Gatwick Airport Northern Runway Project

Environmental Statement

Appendix 9.3.2: Summary of PEIR Responses – Ecology

Application Document Ref: 5.3

ORIENTATION 	DRAWING NO. <b>FIGURE 3.3.1</b>	REVISION <b>For ES Issue</b>
	DRAWN BY <b>MS</b>	PM / CHECKED BY <b>NB</b>

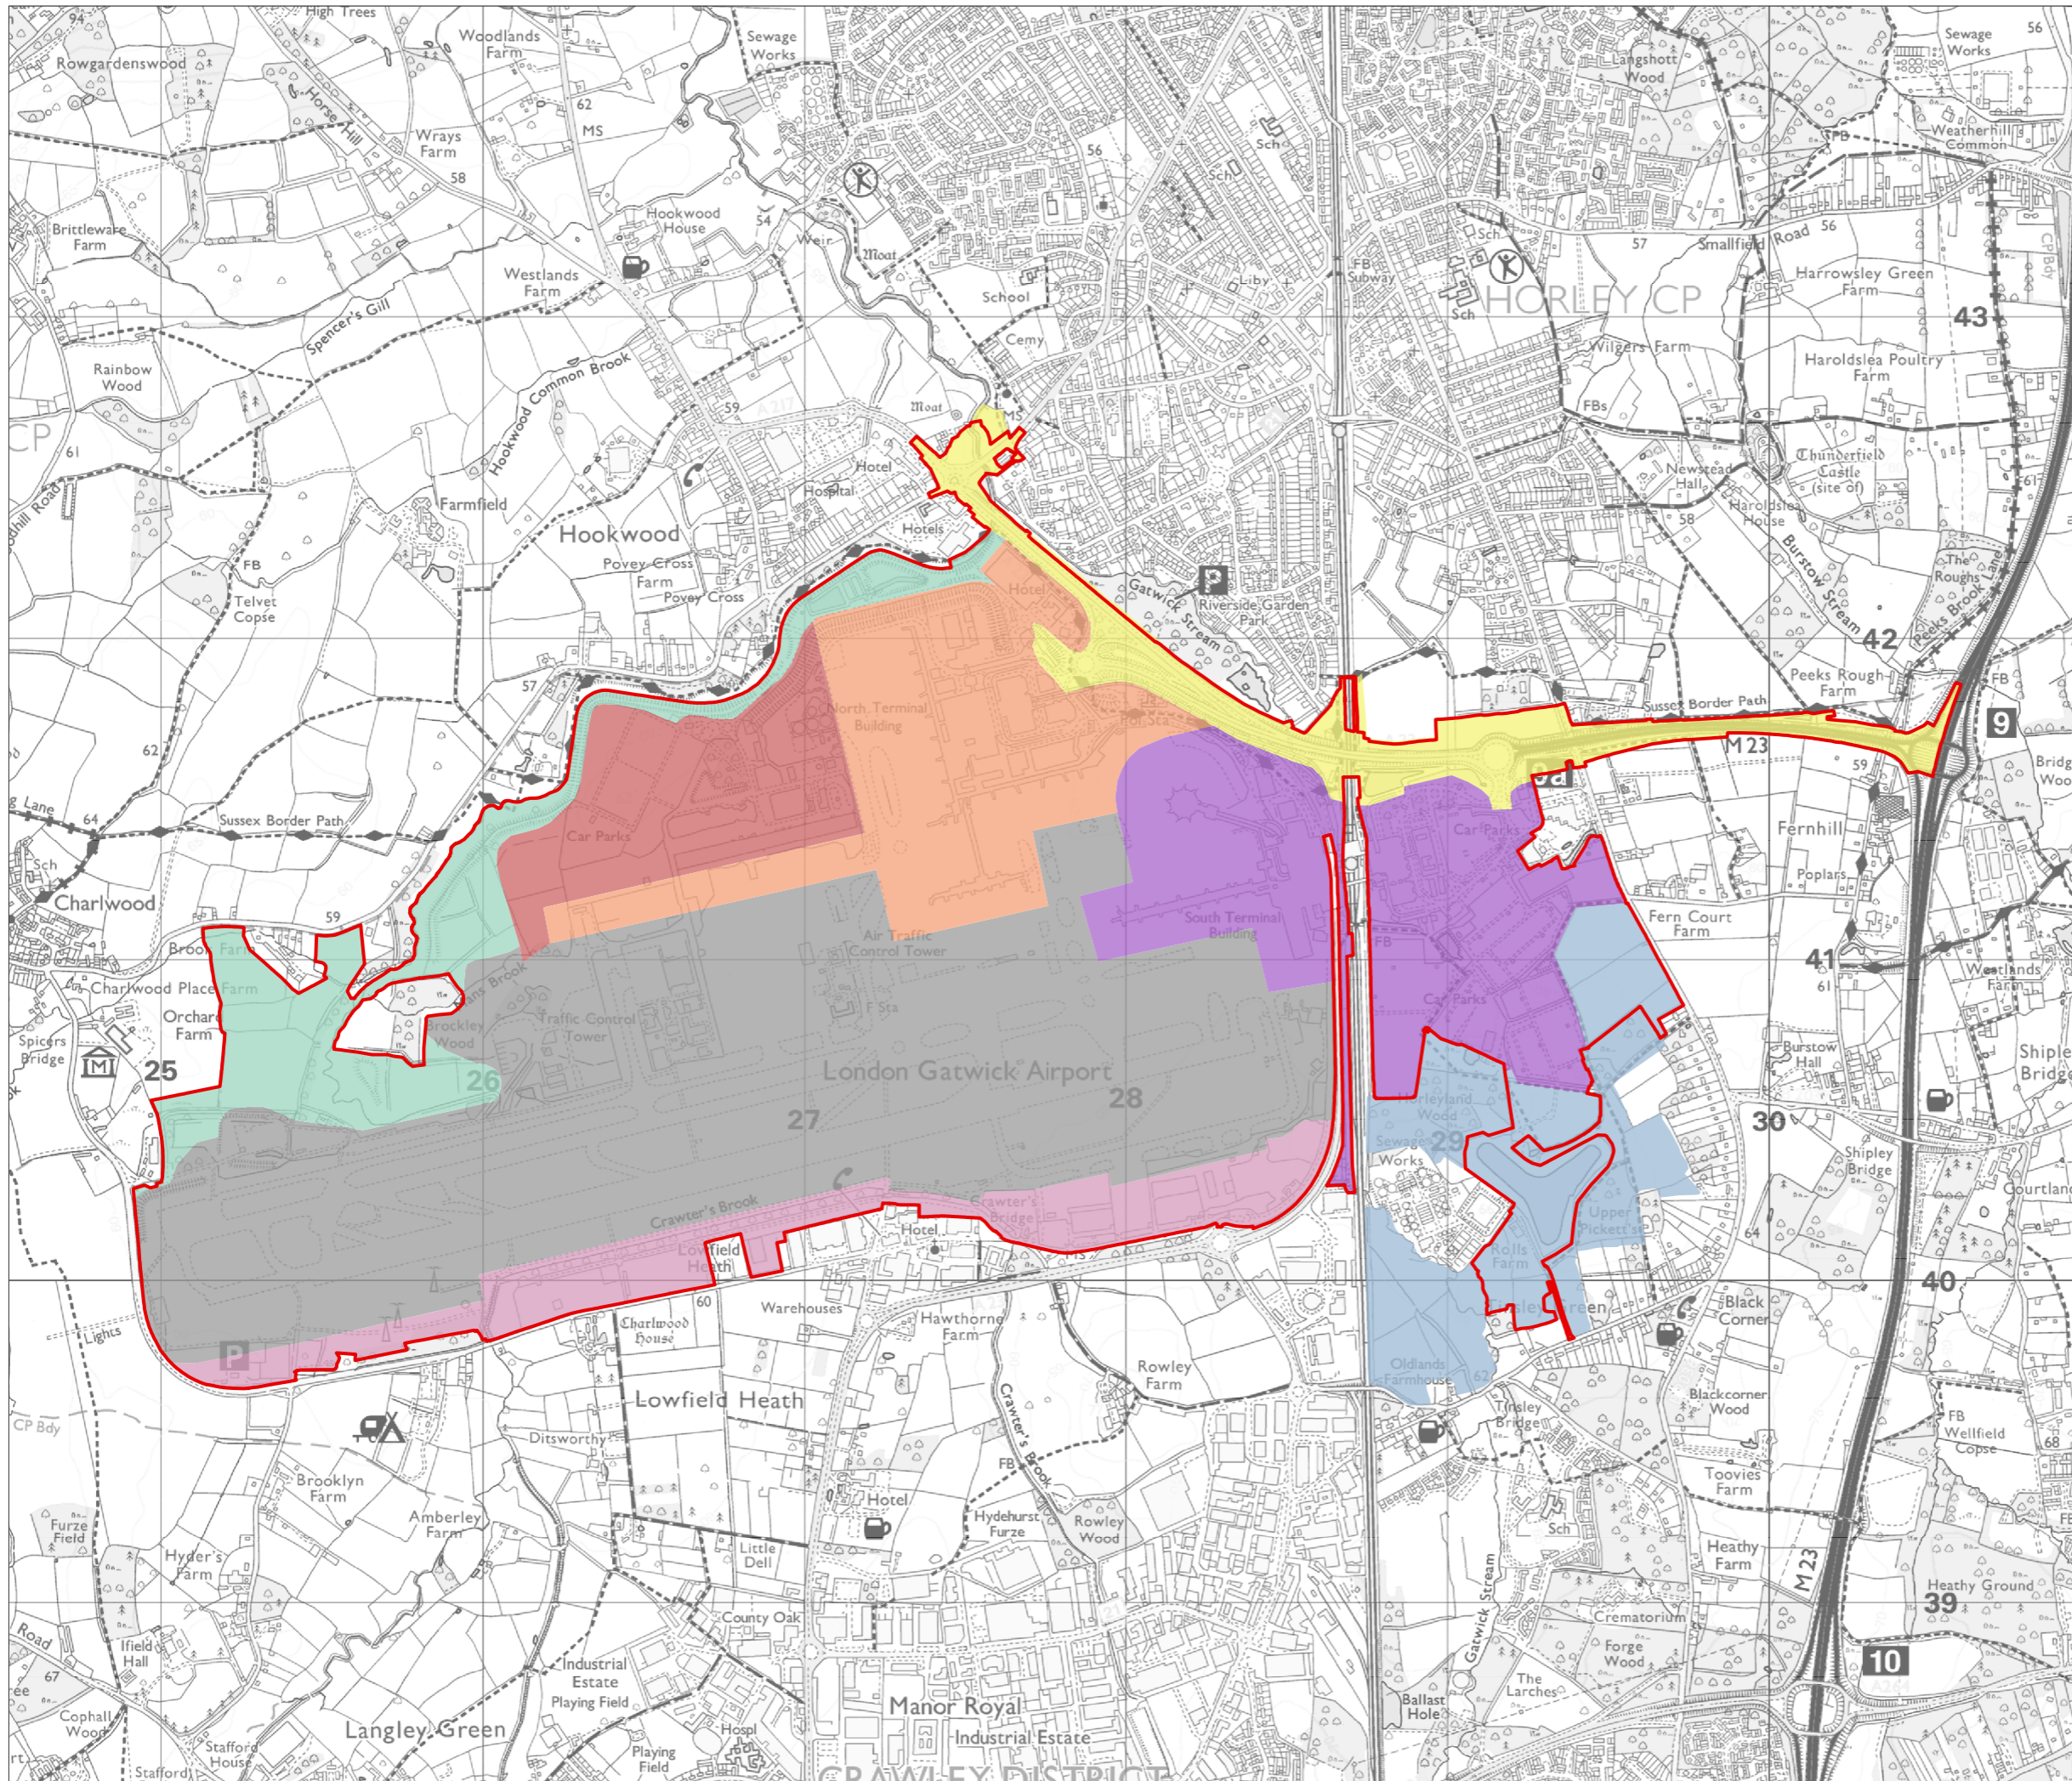
Natural England	1 November 2021	<p>Irreplaceable habitat is afforded robust policy protection in the NPS National Networks and the NPPF. Loss and deterioration are included. It is not clear how the potential deterioration of these habitats has been considered in the PEIR. We advise that the ES should include details of this. If impacts cannot be ruled out, the ES should identify alternative, less damaging options in order to demonstrate the mitigation hierarchy has been followed during the site selection process</p>	Deterioration of ancient woodland has been assessed in Section 9.9 (Chapter 9 of the ES). Table 9.2.1 includes reference to irreplaceable habitats of the NPS and para 180 of the NPPF. Habitat survey reports are described in Section 9.6 and ES Appendix 9.6.2: Ecology Survey Report (Doc Ref. 5.3).
Natural England	1 November 2021	<p>The PEIR does not appear to clearly identify the location of habitats which will be provided to maintain habitat connectivity through the Project Site. We advise that the maintenance of</p>	Figure 3.3.1 of ES Appendix 8.8.1: Outline Landscape and Ecology Management Plan (Doc Ref. 5.3) shows the Ecology

Stakeholder	Date	Details	How / where taken into account in ES
		connectivity is a key factor for this scheme and that the river habitats and woodland and hedgerows surrounding the site are of clear importance for mobile species such as bats.	Strategy for the site, highlighting the improved connectivity that will result from the NRP. Where necessary, temporary impacts to connectivity are assessed and suitable mitigation incorporated to ensure it is maintained.
Natural England	1 November 2021	We advise that the information currently lacks sufficient detail which will be necessary in the ES with regard to the following: <ul style="list-style-type: none"> Revision of value of existing habitat (see below); Quantity of habitat directly lost; Quantity and location of mitigation and compensation areas proposed to address loss and impacts to habitats (and an assessment of current habitats, and function of these habitats (above)). 	The value of existing habitats is provided in Table 9.6.5 of Chapter 9 of the ES. Details of habitat loss and mitigation and compensation areas are provided in Table 9.7.1 and Table 9.8.1 in Chapter 9 of the ES. Details of Biodiversity Net Gain (BNG) are provided in ES Appendix 9.9.2: Biodiversity Net Gain Statement (Doc Ref. 5.3).
